The Coal
Authority

Re: Application 2026/0200

Discharge of conditions 11 (intrusive site investigations) and 12 (signed statement confirming site is safe and stable) relating to application 2023/0941: Erection of 1no. detached dwelling at Highstone Corner, Highstone Lane, Ward Green, Barnsley, S70 6SD

- Proposed grout injection borehole positions.
- NOTES:**
1. Grout injection borehole positions are to be established on site by D&G via coordinated setting out.

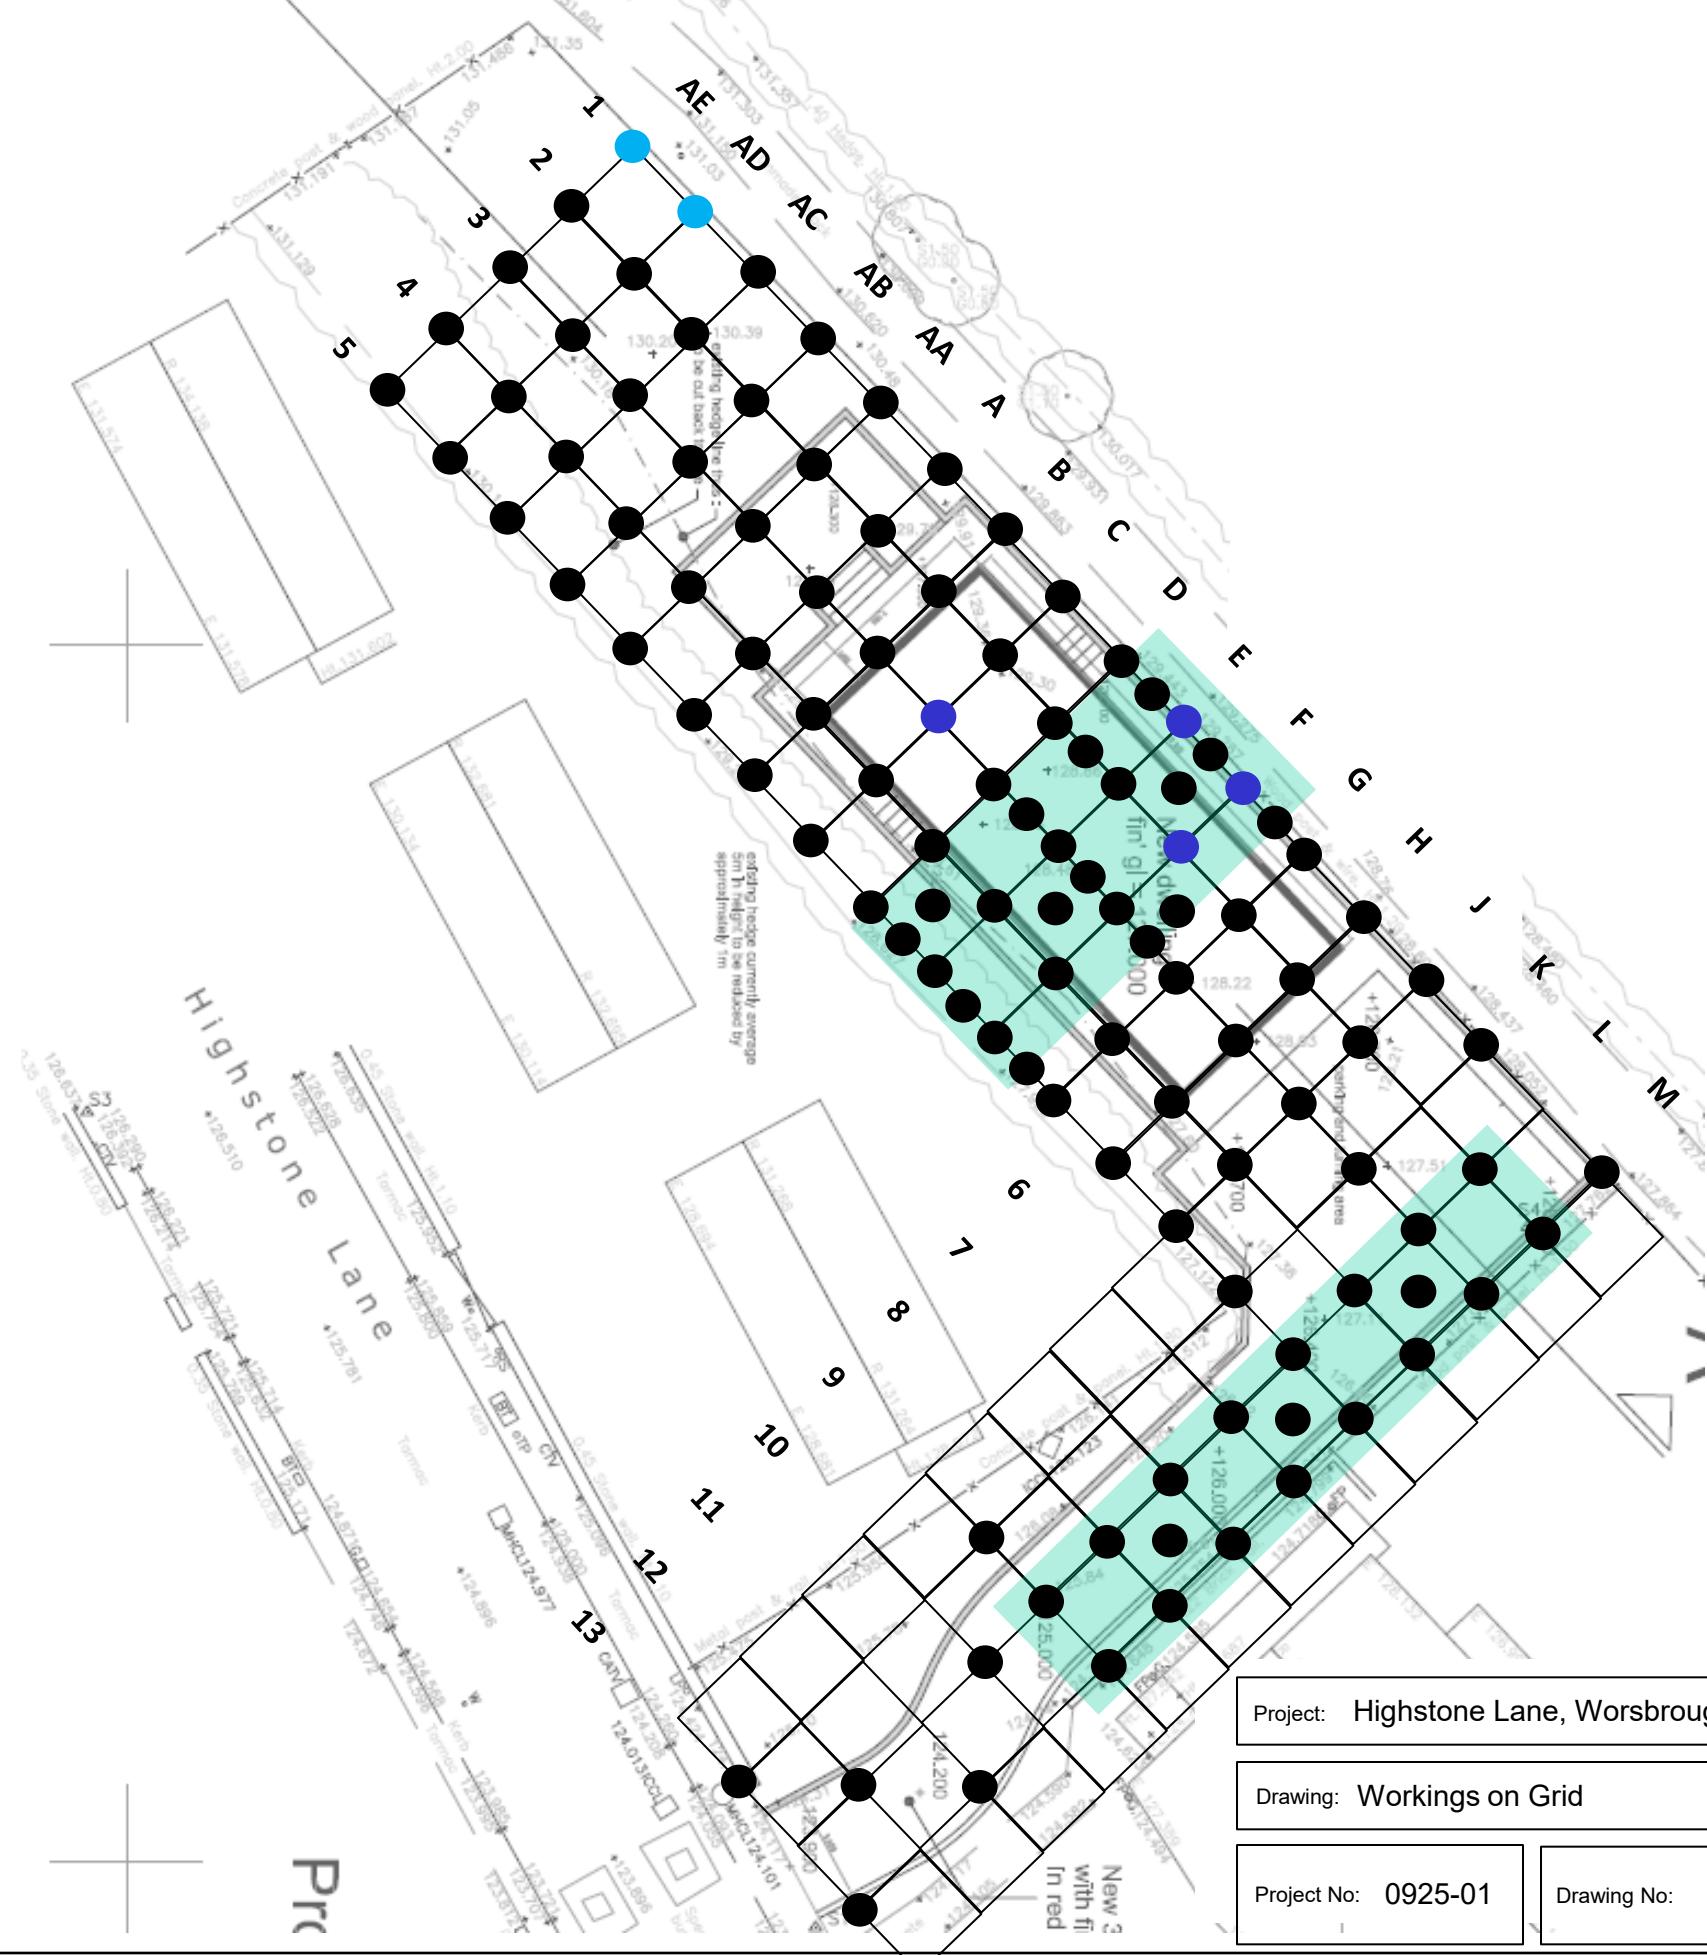
- The report does not address the apparent discrepancy between the results of the grouting works undertaken and the expected shallow coal mining situation given Mining Remediation Authority records and the results of previous investigations that suggest the presence of mine workings at shallow depth beneath the site. We assume that the report author has reviewed the relevant Mining Abandonment Plans in this regard.

- The report does not confirm that works to locate all mine entries that could potentially be present within the site have been carried out and that all mine entries present within the site have been suitably remediated.

- The 53° bearing of adit 434404-13 (shown on geological plans and Mine Abandonment Plans) is such that any roadway associated with this feature would be expected to extend beneath the site, under or close to the proposed dwelling. The report suggests that no evidence of this feature was encountered during drilling and grouting works. No hypothesis is advanced as to why it was not found. Should it be the case that the report author considers that it lies beneath the depth of drilling and grouting works carried out, consideration should be given to whether sufficient cover will overlie the adit to ensure the stability of the dwelling.
